Rezoning Transportation Analysis

Petition Number: #2021-120

Date	Description
09-28-2022	First Review (AO)
10-27-22	Second Review (TM)

Revised Site Plan 10.17.22

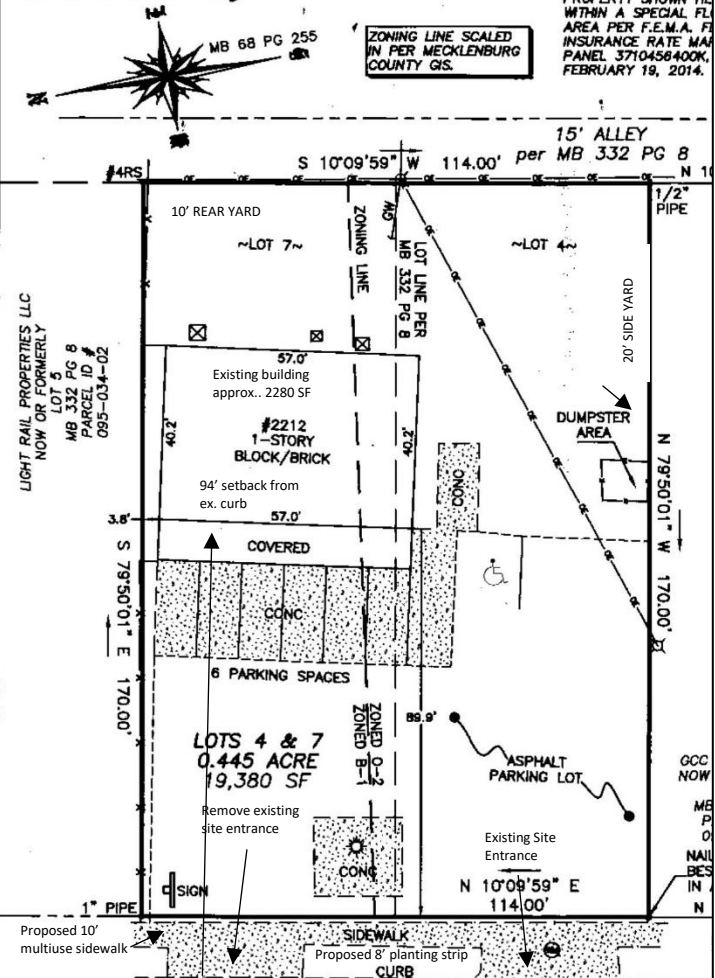
3. Revise site plan and conditional note(s) to commit to dedicate minimum 50 feet of right-of-way from the road centerline of The Plaza if it does not currently exist. The site plan shall label and dimension the right-of-way from the road centerline.

Clarifying Comment 10-27-22: Dimension right-of-way from the centerline of the roadway. Add conditional note committing to dedicating 50-feet of right-of-way if it does not currently exist.

Updated Comment 10-27-22: Revise site plan and conditional note(s) to commit to construct a 8-foot planting strip, and 10-foot multi-use path on The Plaza. The site plan shall label and dimension both items from the back of curb and gutter.

5. **Outstanding Comment from 9-28-22:** Revise site plan and conditional note(s) to commit to removing existing bike ramp and green pavement markings just north of site. The site plan shall label and dimension both items from the back of curb and gutter.

Updated Comment 10-26-22: Revise site plan and conditional note(s) to commit to restriping existing green pavement marking to a dedicated right turn lane and removing existing bike ramp just north of the site. The site plan shall label and dimension both items from the back of curb and gutter.

7. ~~Comment from 9-28-22:~~ Revise site plan and conditional note(s) to commit to remarking pavement markings and building a bike ramp near south property line to transition bicyclists from separated bike lanes to multi-use path.

Updated Comment 10-26-22: After further coordination the above design has been updated as follows to. Revise site plan and conditional note(s) to commit to remarking current bike lane pavement markings to a dedicated right turn lane, a bike ramp near south property line per CLDSM 10.43 to transition bicyclists from separated bike lanes to multi-use path and extending the 10-foot multi-use path to the southern property.
